Please use the latest checklist from 2021 on the EPC website <https://publicworks.elpasoco.com/stormwater/>

EPC STORMWATER REVIEW COMMENTS IN ORANGE BOXES WITH BLACK TEXT

GRADING AND EROSION CONTROL PLAN CHECKLIST

DESIGNED BY:	MD	SCALE	DATE ISSUED:	AUGUST 2026	DRAWING No.
CHECKED BY:	DAD	HORIZ	SHEET	6 OF 13	GEC03

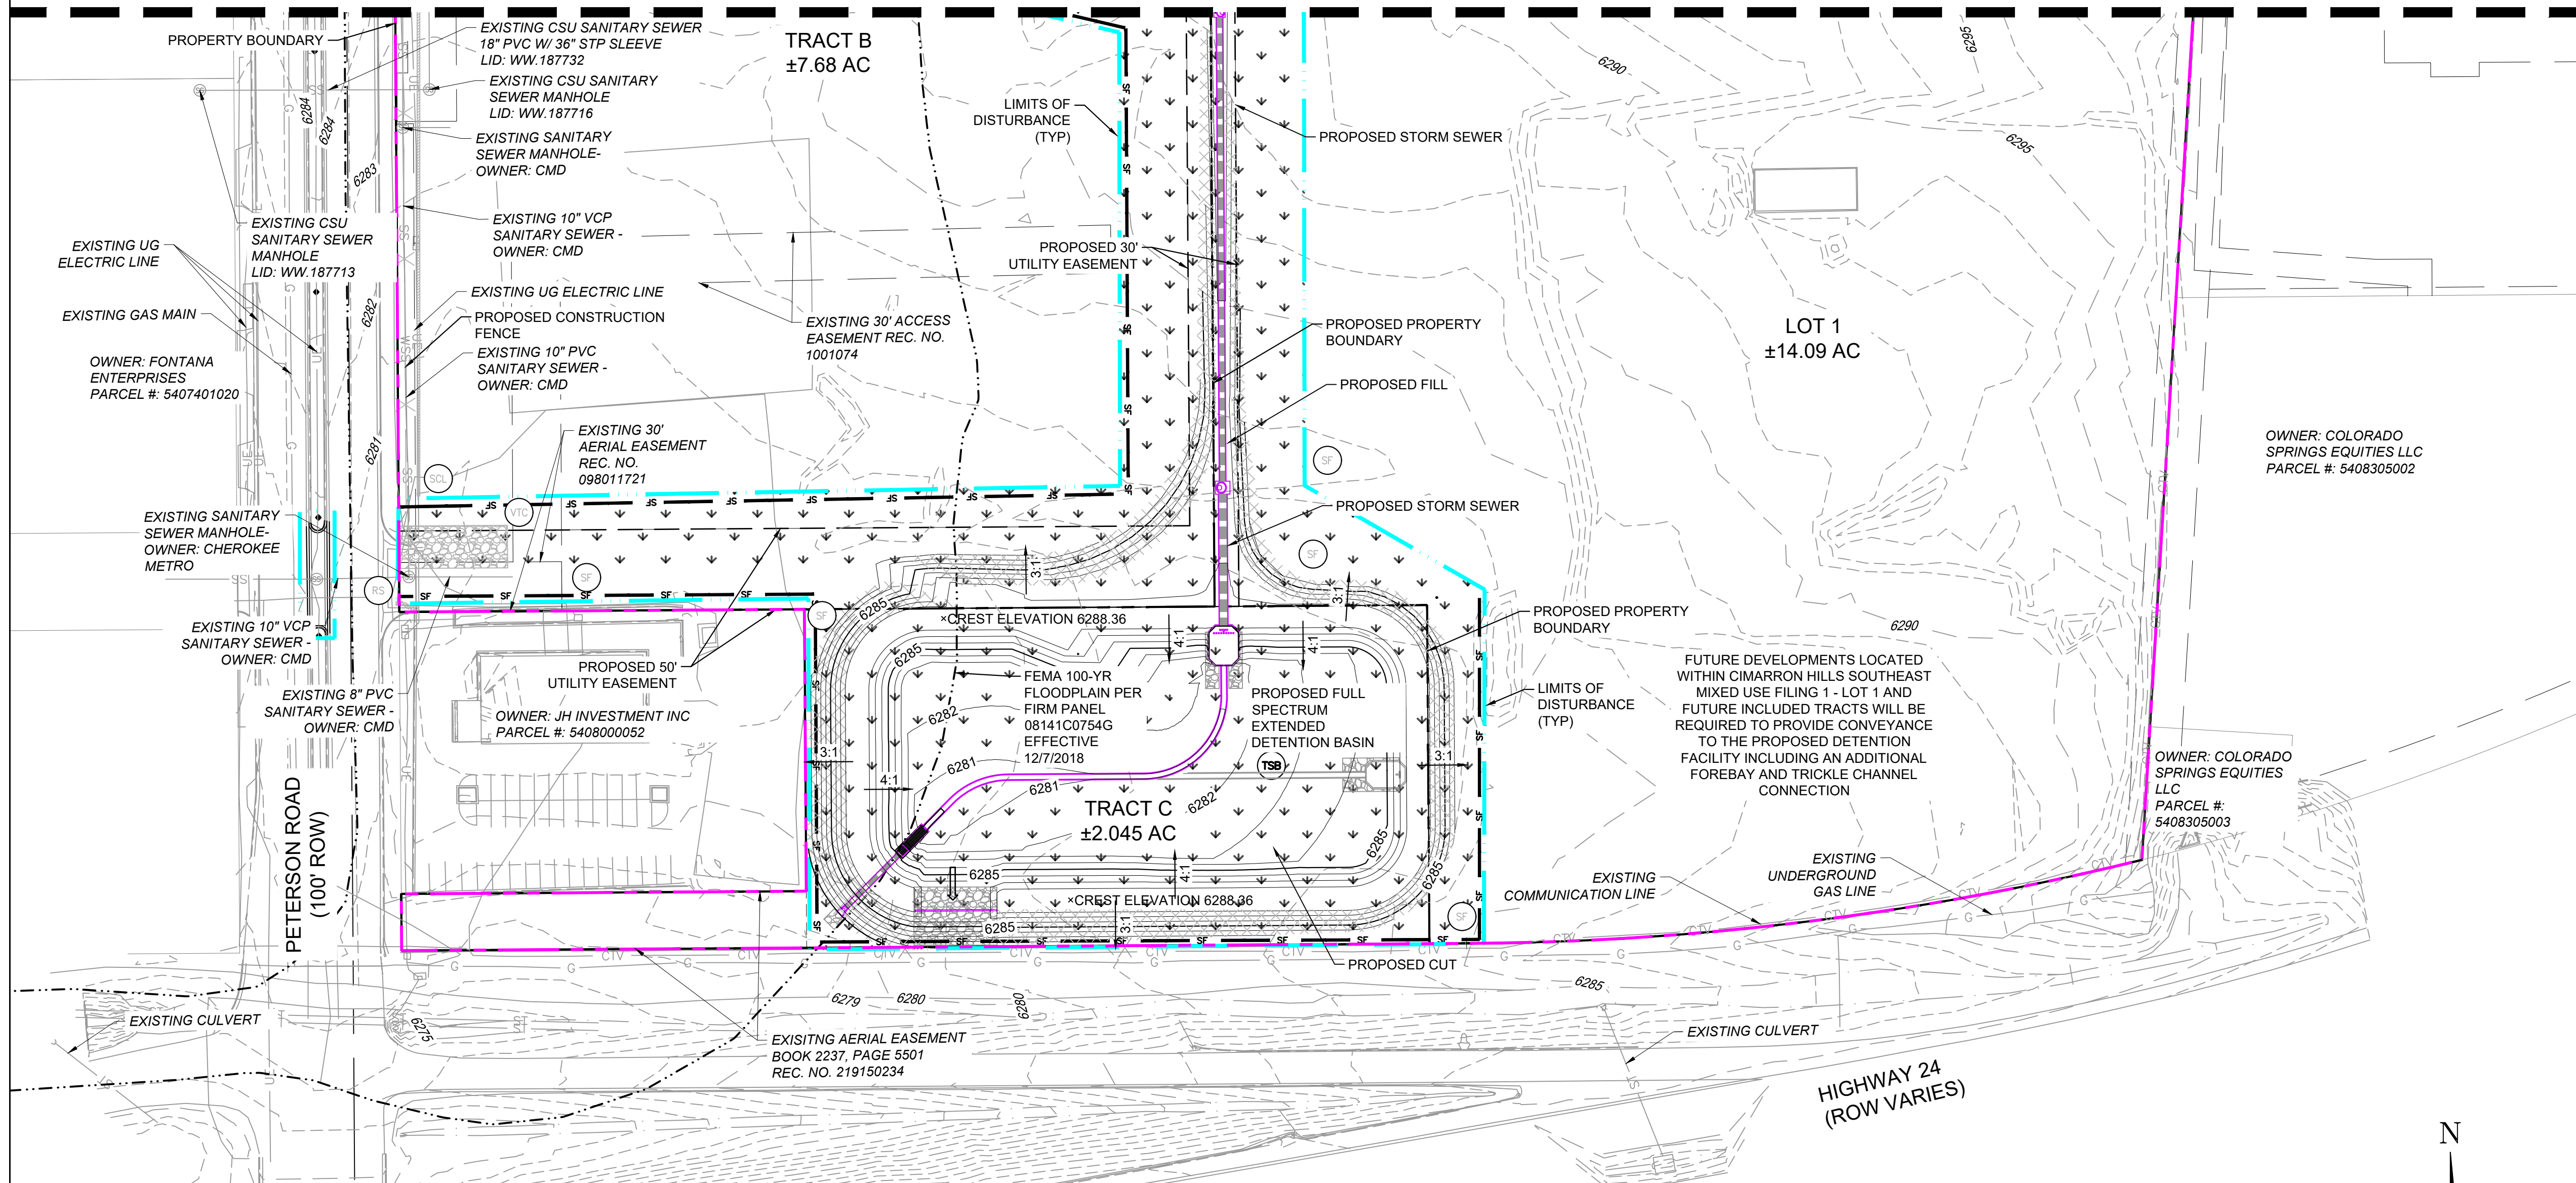
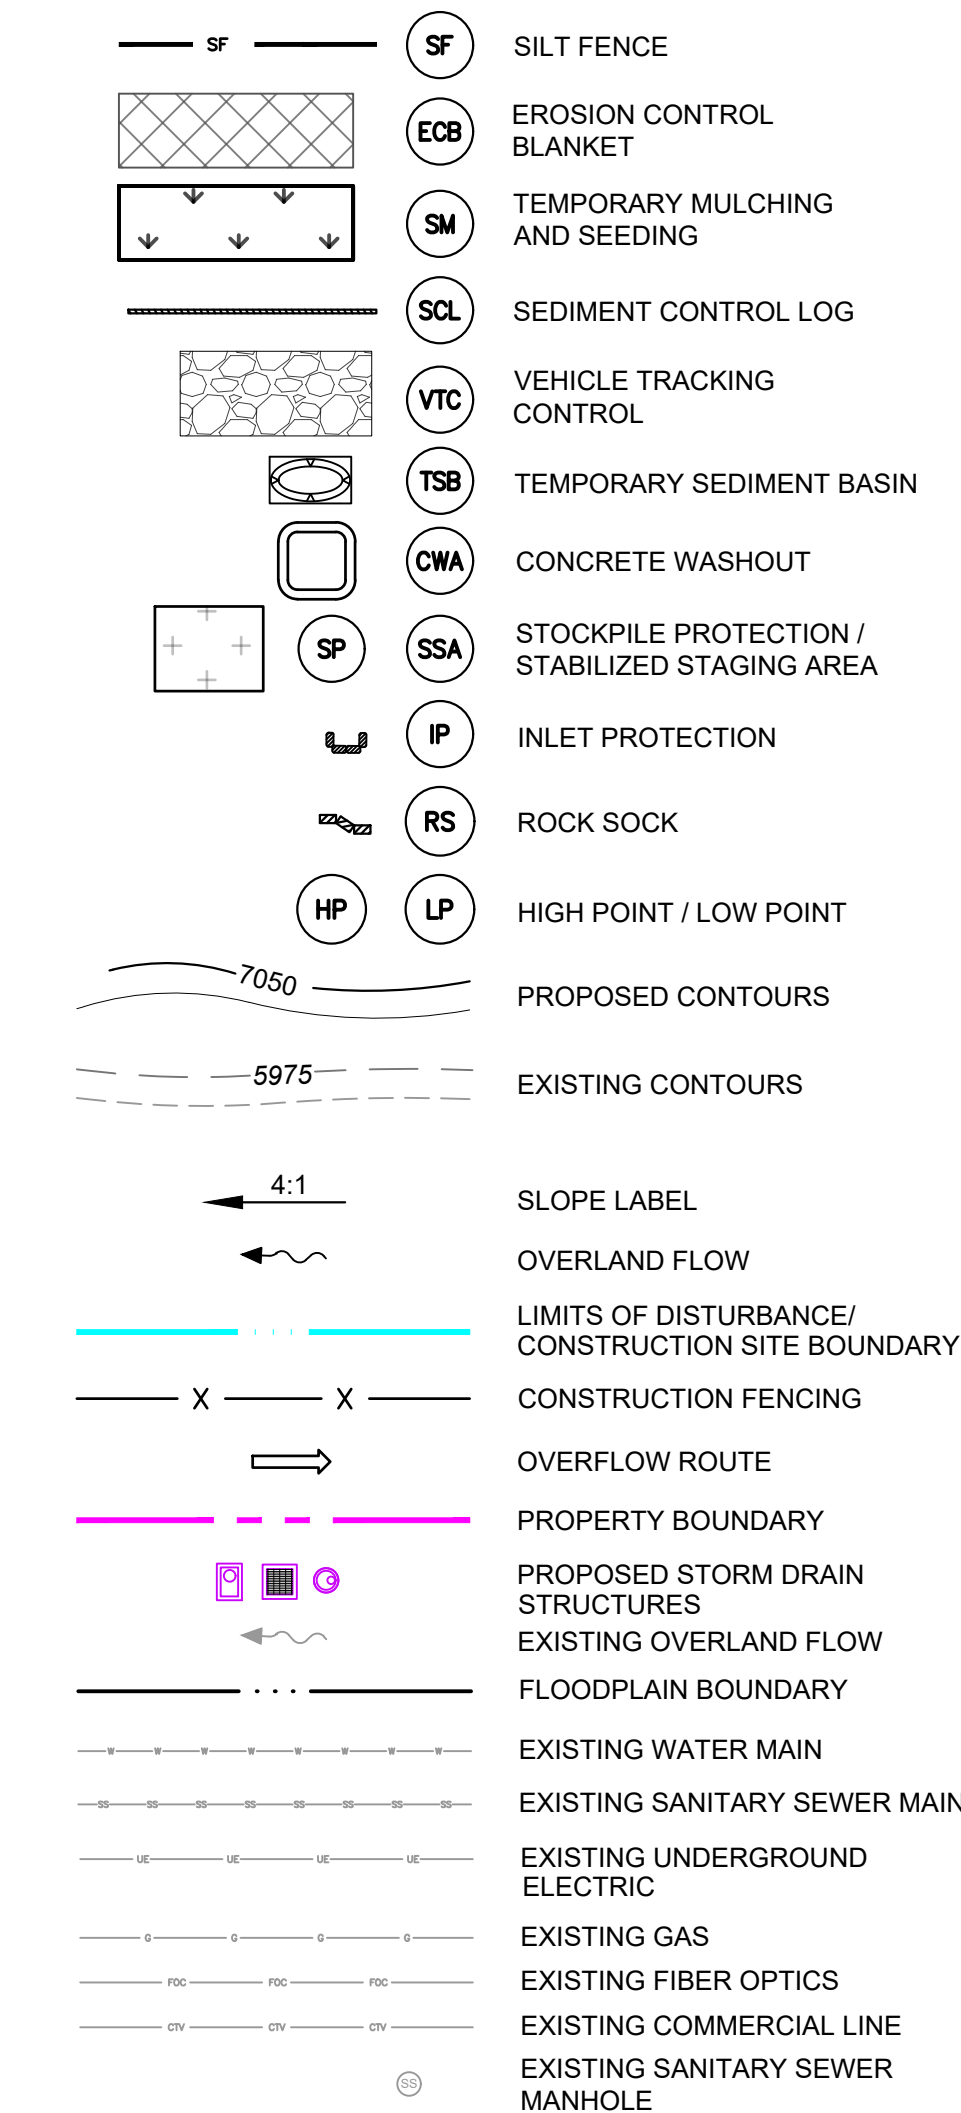
add to GEC
ECB called out
on Sheet
GEC03
